DRB Project Number: 2025-020024 Hearing Date: 05-21-2025  
Project: Lot/Tract 1, 2, MITCHELLS--J C  
FIRST ADDN, located at  
1614 WILLIAM STREET SE  
between WILLIAM STREET SE  
AND SOUTHERN AVENUE SE Agenda Item No: 5

### Planning - Case Comments

**Project Name:** 1614 Williams St SE

**Request:** Minor Preliminary Plat to Consolidate two lots into one

Plat for
Lot 1-A, Block 2
J.C. Mitchell Addition No. 1
Being Comprised of
Lots 1 and 2, Block 2
J.C. Mitchell Addition No. 1
City of Albuquerque
Bernalillo County, New Mexico
April 2025

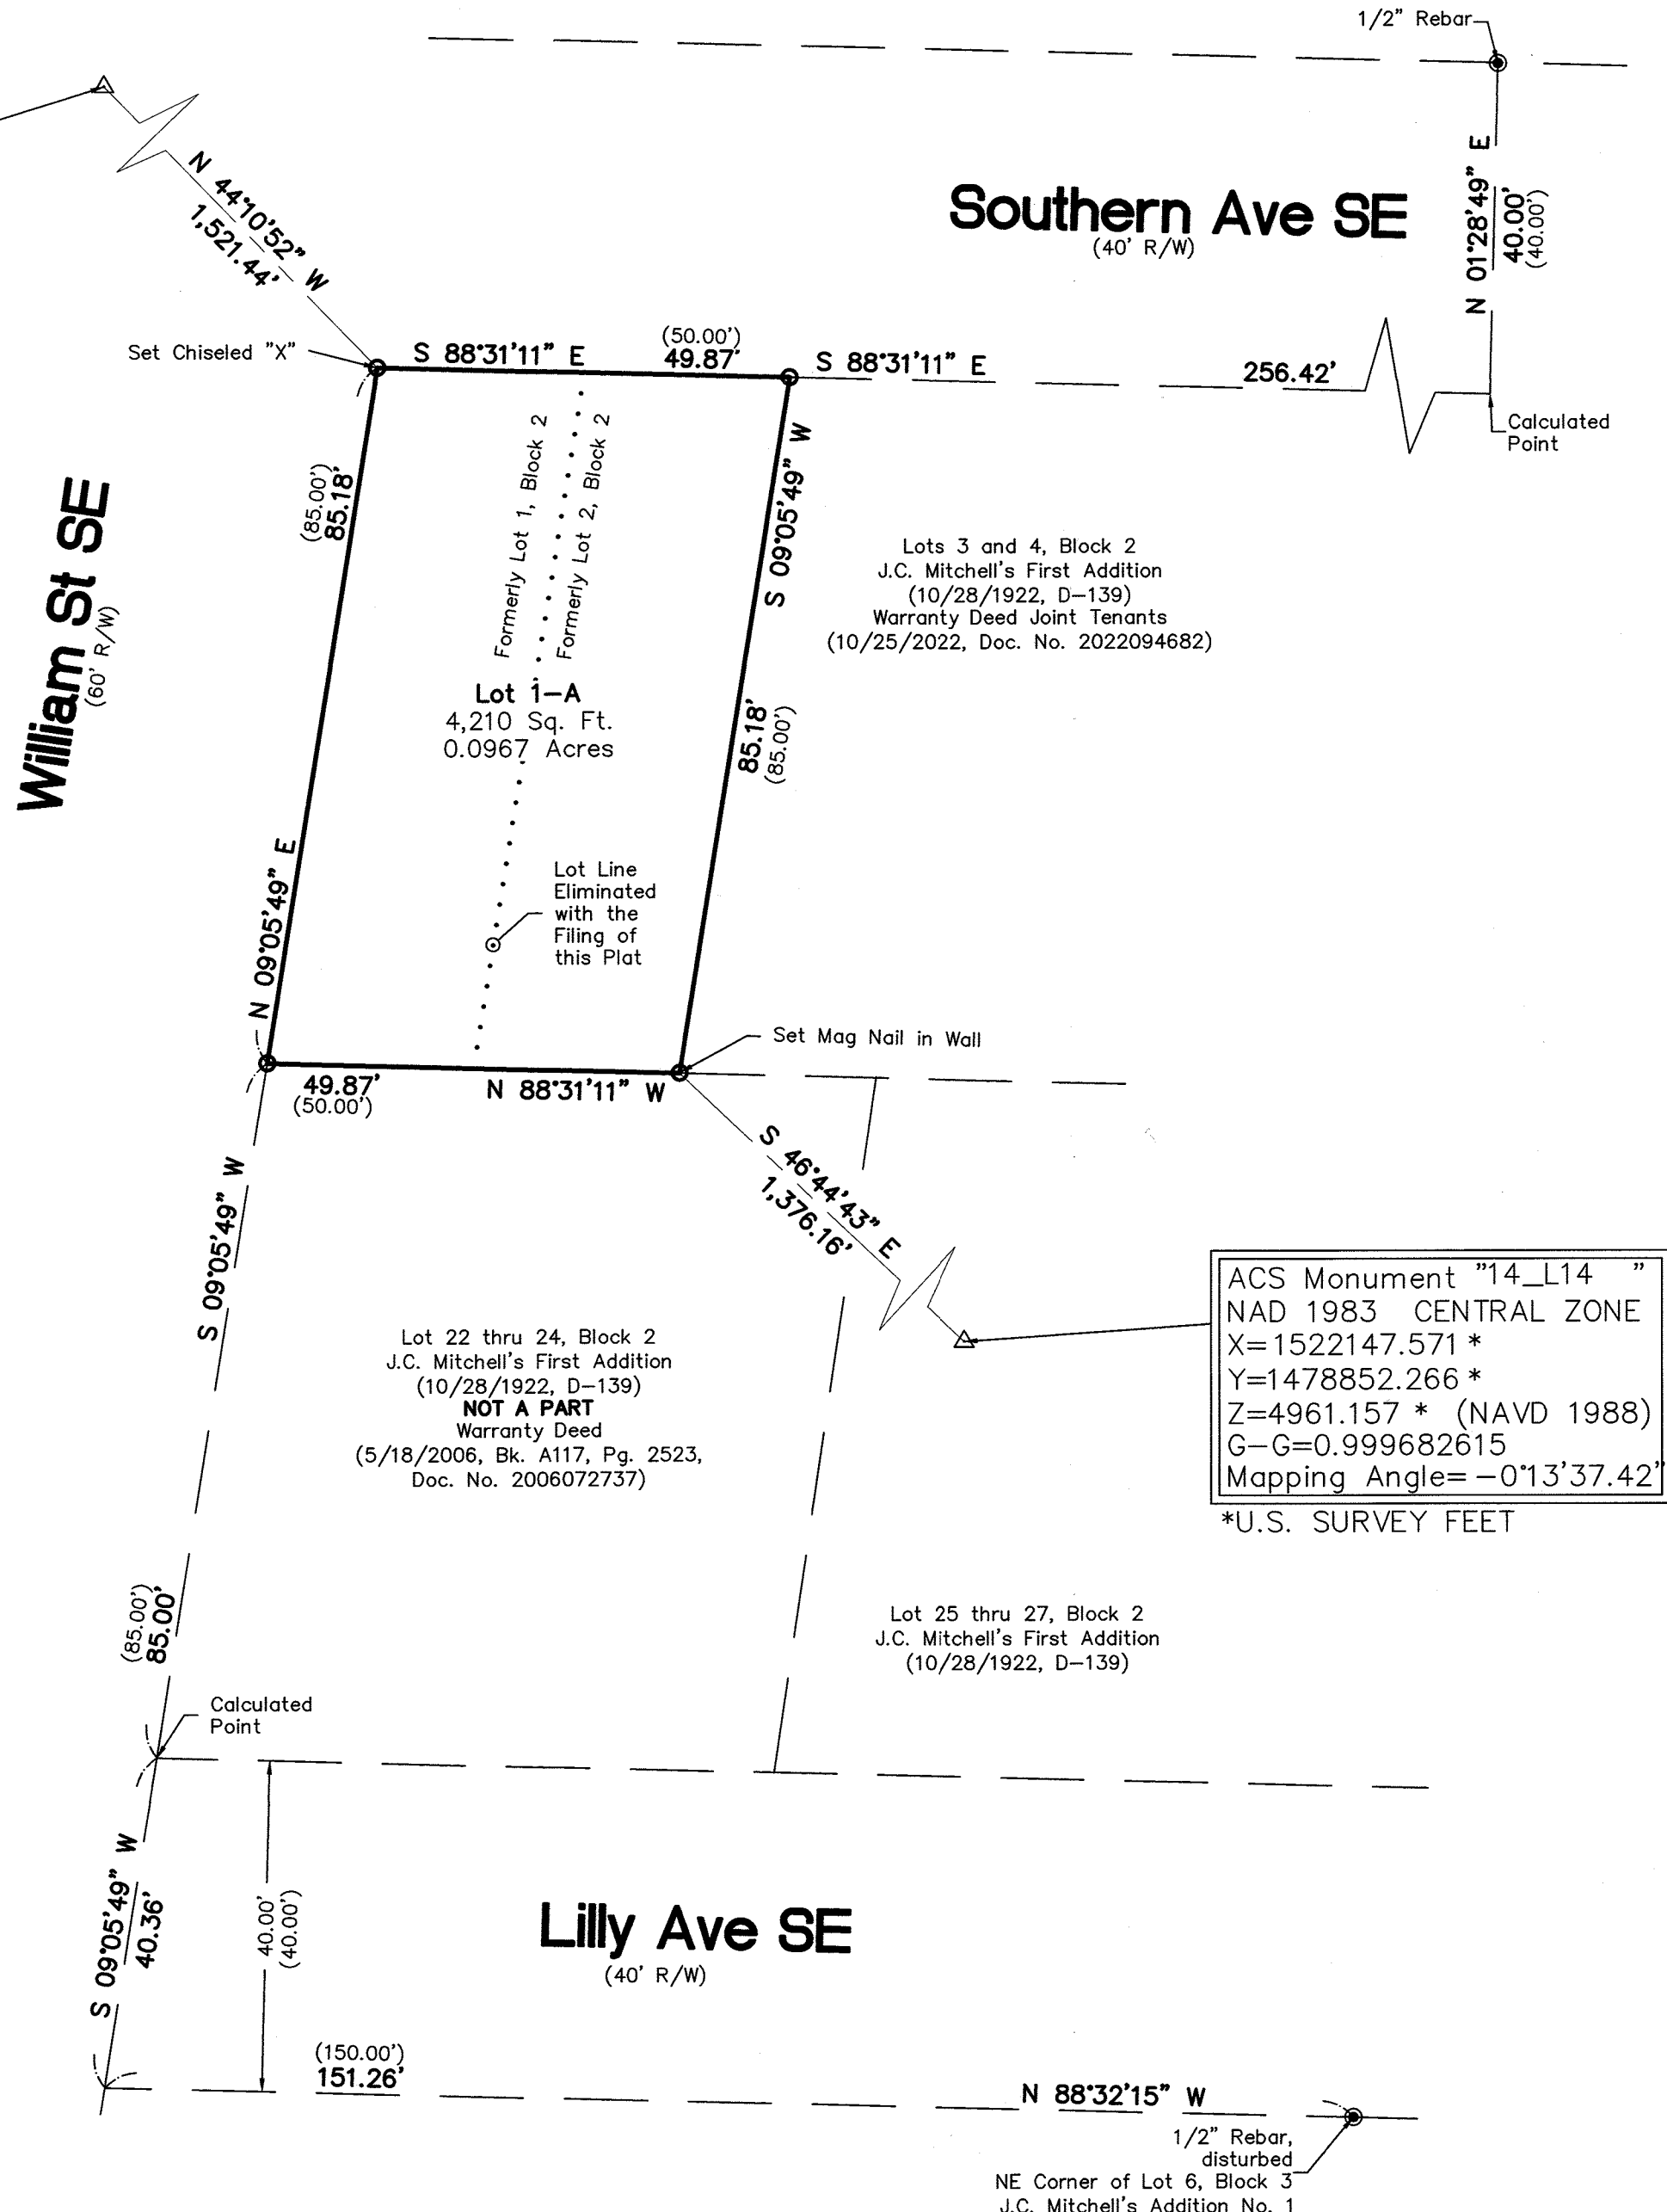
- The required signatures from the surveyor, property owner(s) and the City Surveyor are featured on the Plat.
- Project and application numbers must be added to the Plat.

- A note must be added to the Plat, which records the requests (approvals) of these determinations from the DHO.
